re: Planning Applications Received by Welwyn Hatfield Council

Application No.	Description and Location	Applicant/Agent
S6/2014/0232/FP	Change of Use of part of ground floor from House in Multiple Occupation (class C4) to three self contained units (class C3) 2 De Havilland Close Hatfield AL10 0DR	Ms K Crowder-James Contour Planning Services Weltech Centre Ridgeway Welwyn Garden City AL7 2AA

ADDRESS:	2 DE HAVILLAND CLOSE, HATFIELD, HERTS. AL10 0DR		
DRAWING TITLE:	PROPOSED PLANS		
DRAWING STATUS:	PROPOSED	SCALE:	1:100
DRAWN BY:	DP	DATE:	JAN 2014
DRAWING NO:	P100	REVISION:	A

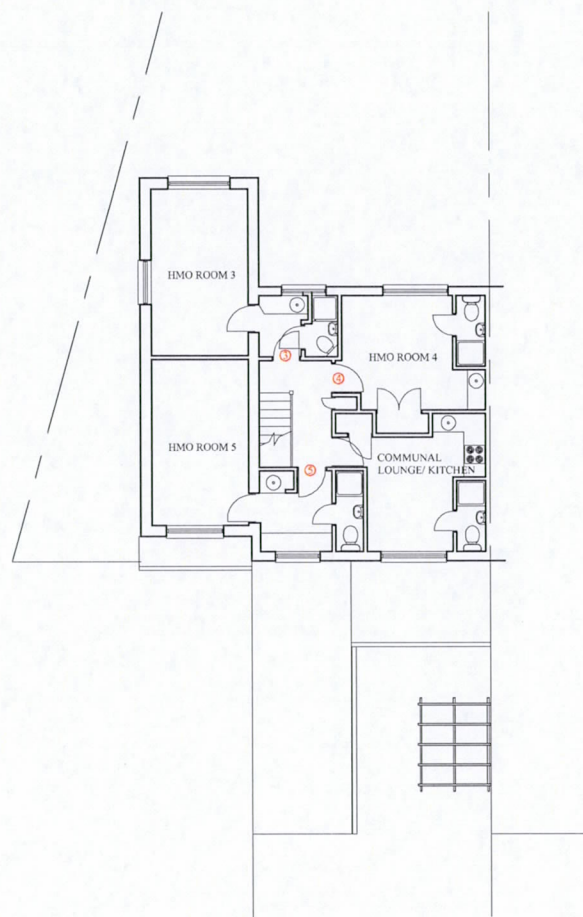
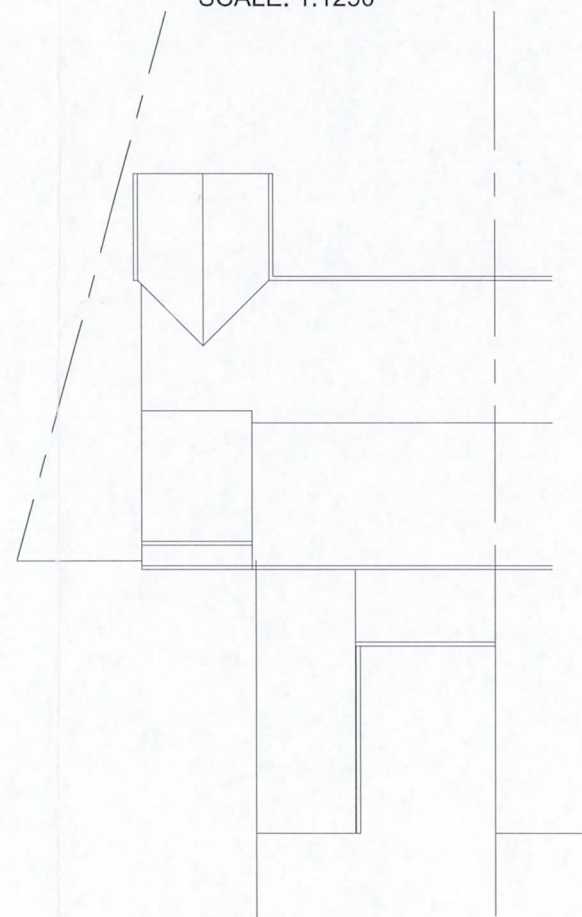
Drawing no P100 – Proposed

1. Could you kindly confirm there is level entry into all proposed ground floor dwellings with unencumbered approaches?
2. Could you kindly the widths of the ground floor entrance doors
3. Could you kindly confirm there are accessible toilets in all the proposed ground floor dwellings?
